City of Portland, Maine - Building or Use Permit Application

Permit No: 04-0822	Issue Date: JUL 19 2004	CBL: 341 G027001
-----------------------	----------------------------	---------------------

Location of Construction: 28A D B Carriage Ln lot #7	Owner Name: Wa One	Owner Address: Po Box 10127	Phone:
Business Name:	Contractor Name: Dwight Brackett	Contractor Address: 84 Country Lane Portland	Phone: 2077728629
Lessee/Buyer's Name	Phone:	Permit Type: Single Family	Zone: R-S
Current Use: Vacant Lot	Proposed Use: Multi - Family 2-unit/ Build a 34x40 2 story Dwelling 30	Permit Fee: \$1,311.00	Cost of Work: \$135,000.00
		CEO District: 5	
Proposed Project Description: Multi - Family 2-unit/ Build a 34x40 2 story Dwelling 30'x40' per D.B. 7/9/04		FIRE DEPT: <input checked="" type="checkbox"/> Approved <input type="checkbox"/> Denied	INSPECTION: Use Group R-3 Type SB BOCA 1999
		Signature: [Signature]	Signature: [Signature]
		PEDESTRIAN ACTIVITIES DISTRICT (P.A.D.)	
		Action: <input type="checkbox"/> Approved <input type="checkbox"/> Approved w/Conditions <input checked="" type="checkbox"/> Denied

Date - New Development permit #04-0822

**FOUNDATION / FIRST FLOOR FRAMING PLAN**

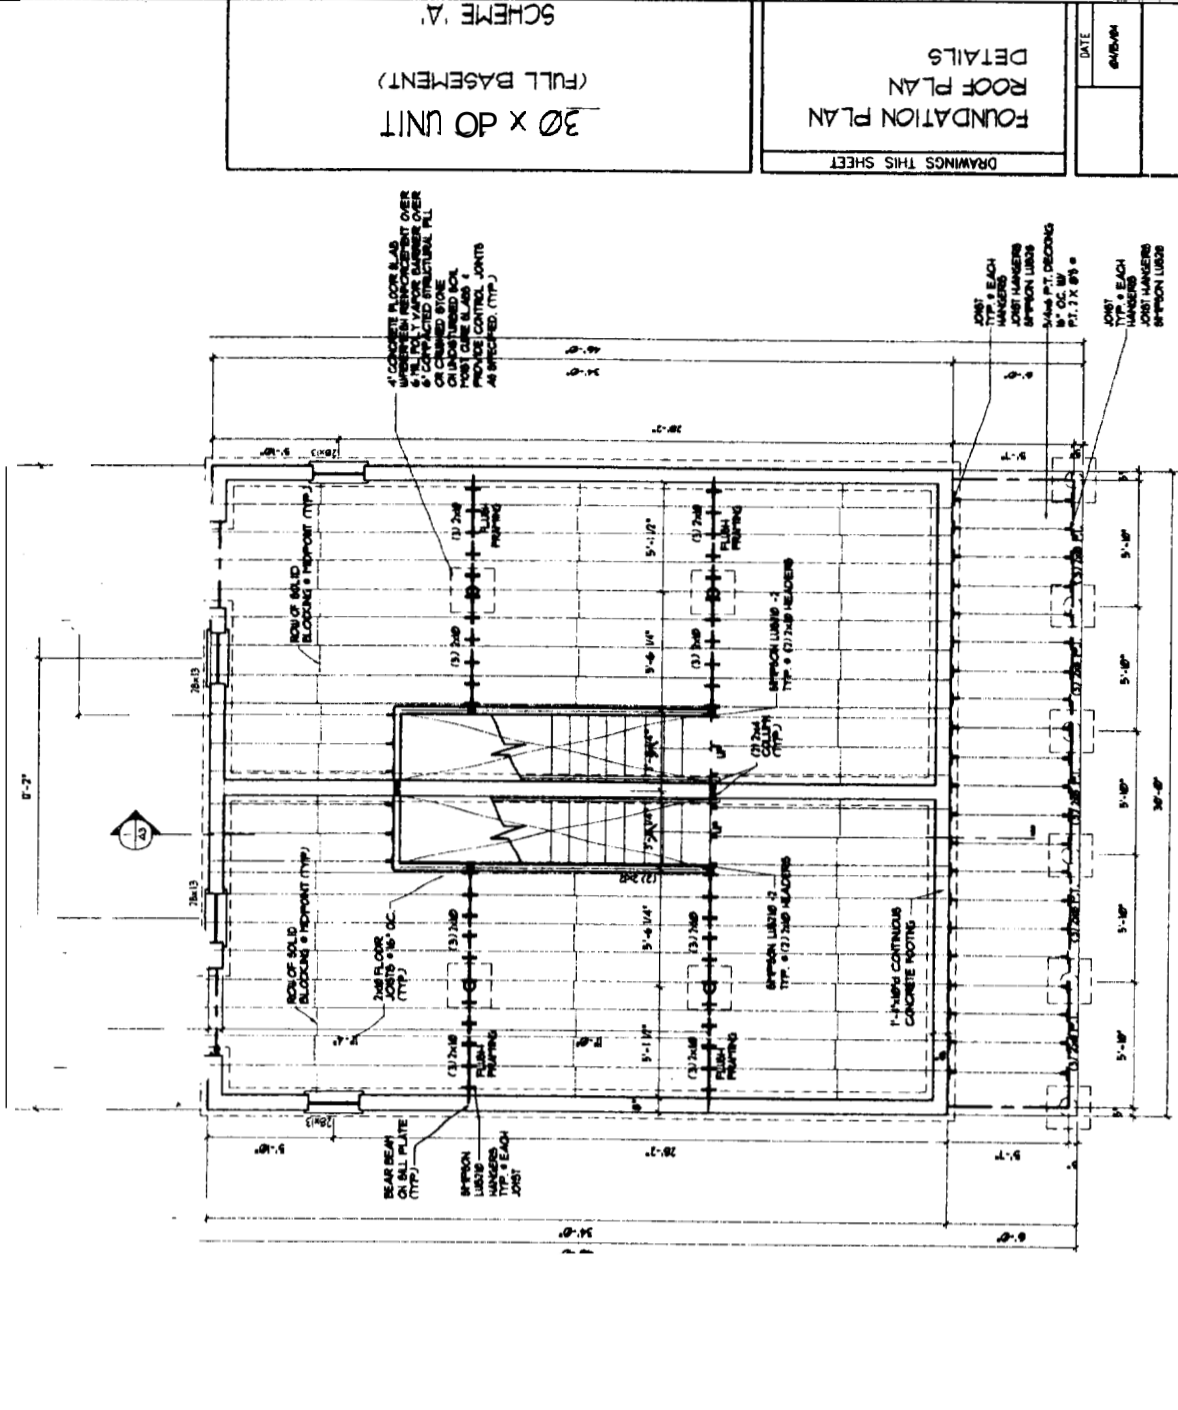
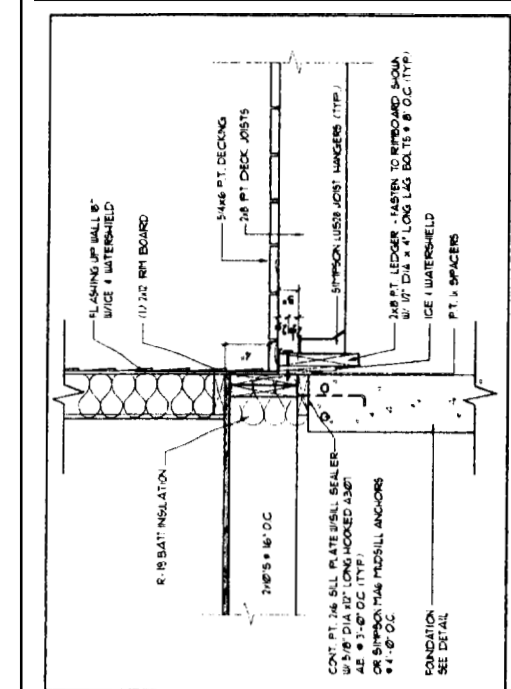
Footing Dimensions/Depth (Table 403.1.1 & 403.1.1(1), Section 403.1.2) OK Shows 8' - 7 1/2" want over Dwight

Foundation Drainage Damp proofing (Section 406) OK Note #1 sheet R2 - Shows drainage - need A1 for fabric

Anchor Bolts/Straps (Section 403.1.4) 5/8" @ 3' oc - OK

Lally Column Type, Spacing and footing sizes (Table 502.3.4(2)) OK - 3-2x10's - 5 1/2' largest span

**Lot 7 Lot Layout and Utility Plan**  
CARRIAGE LANE

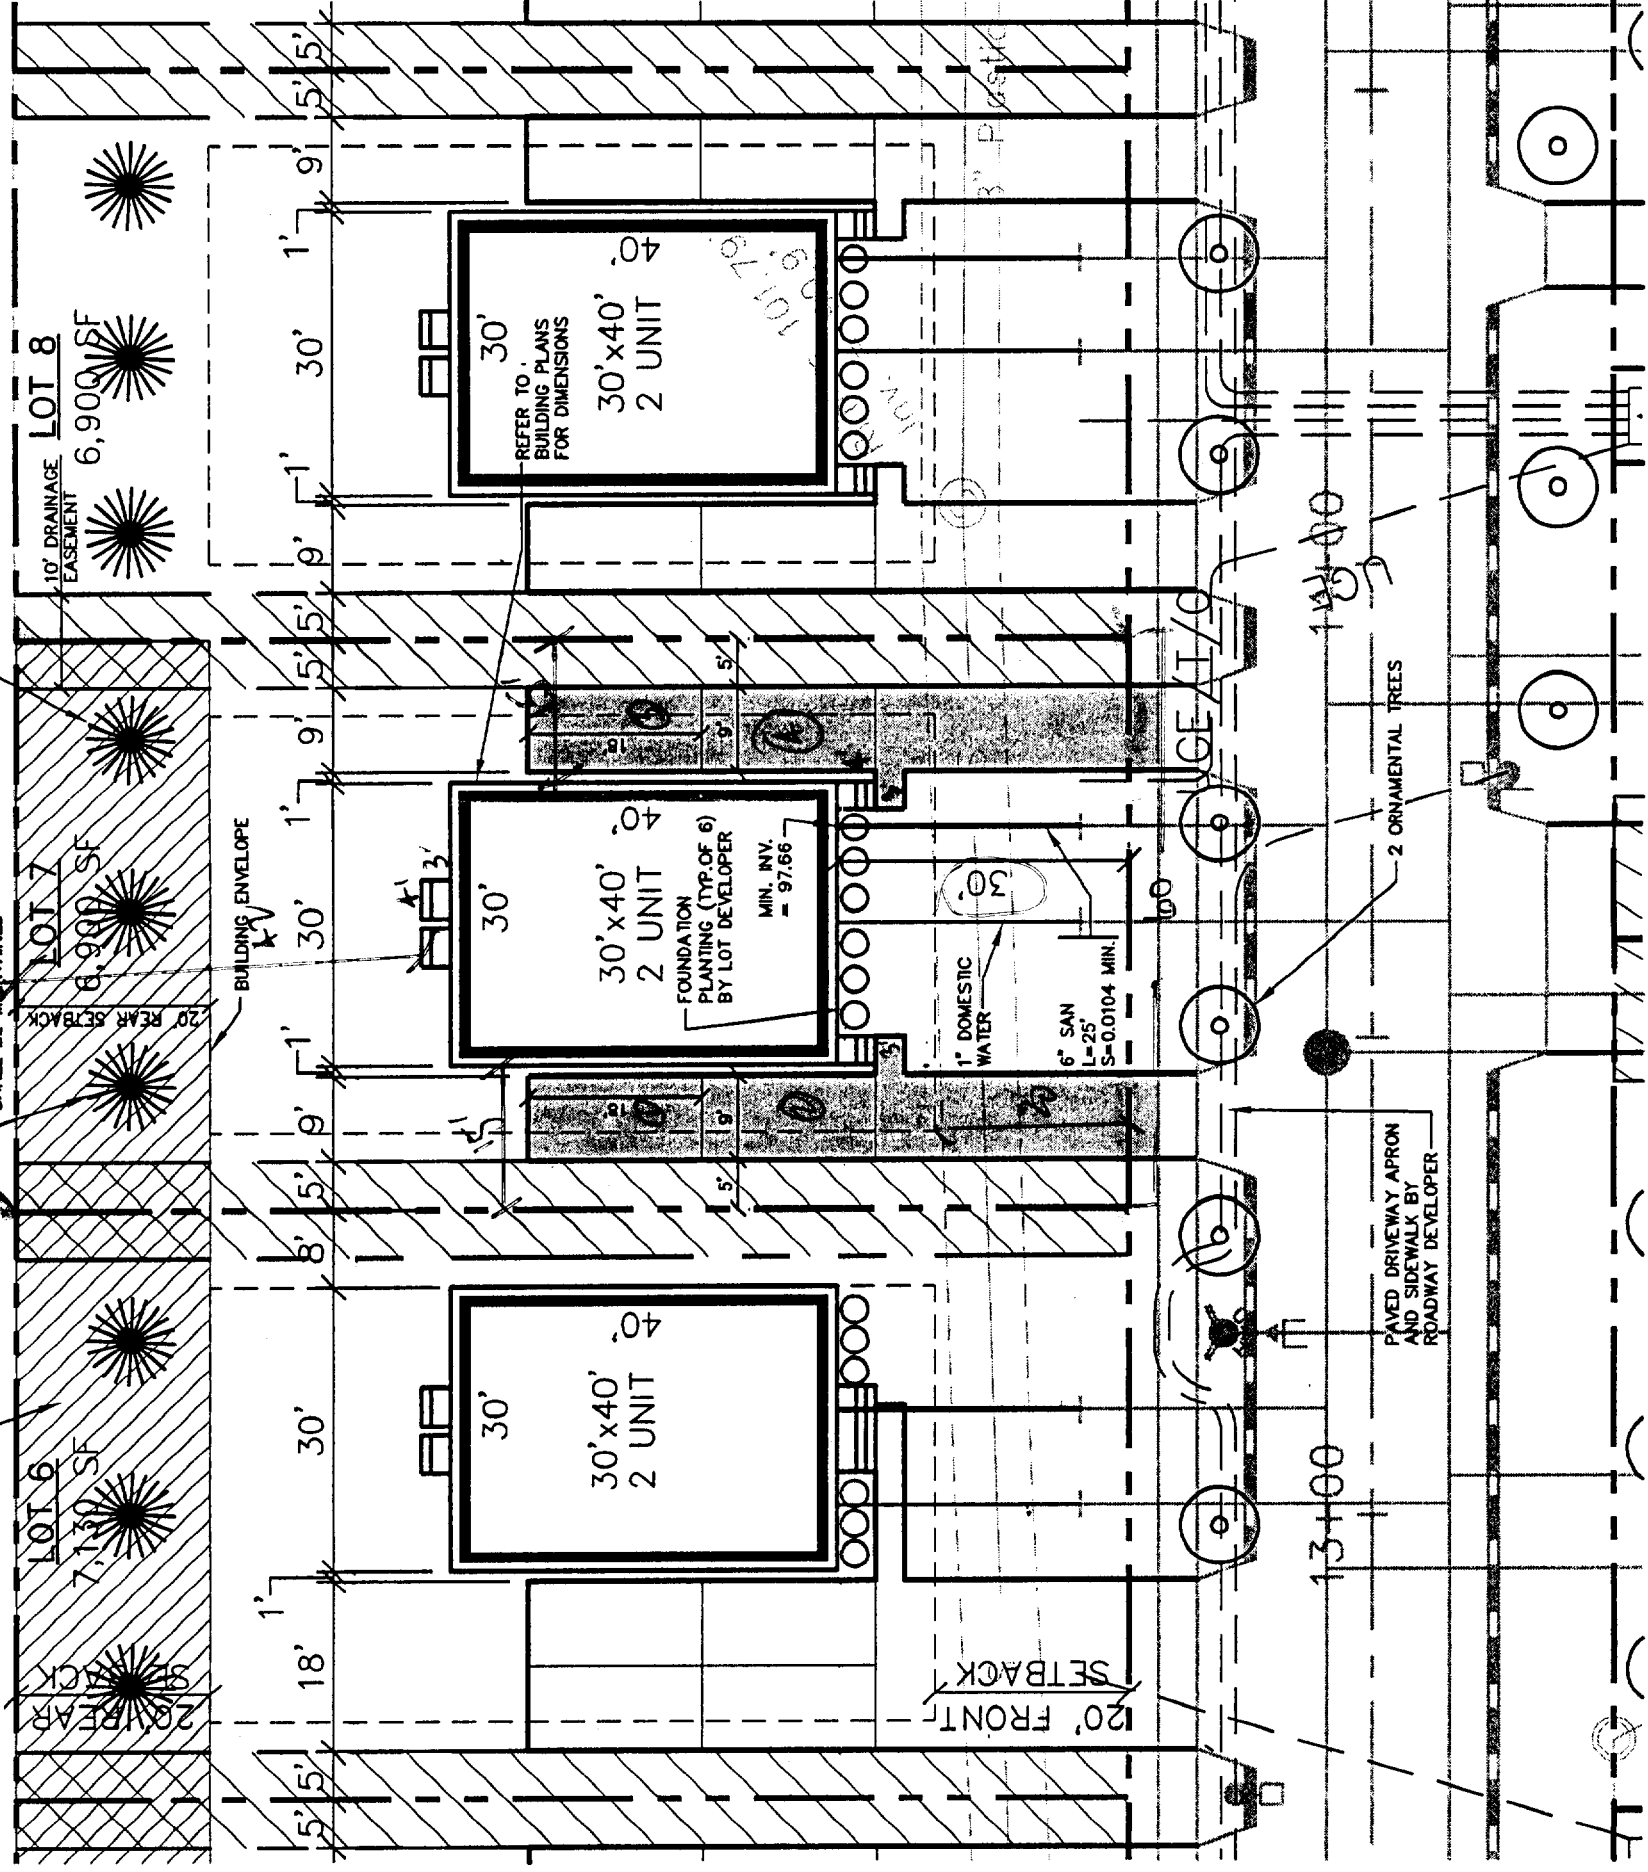
Lot Street Frontage - 50' min req - 60' scaled

Front Yard - 20' min req - 30' to bldg

Rear Yard - 20' min req - 42' to rear

Side Yard - 12' min req - 15' & 15' shown

Projections - 2 front ^{3' x 4'} stoop & stairs - 2 rear ^{3' x 4'} stoop & stairs - No rear Bulkhead

Off-street Parking - 2 per D.U. or 4 pkg spaces req - 4 pkg spaces shown behind 20' req. set back
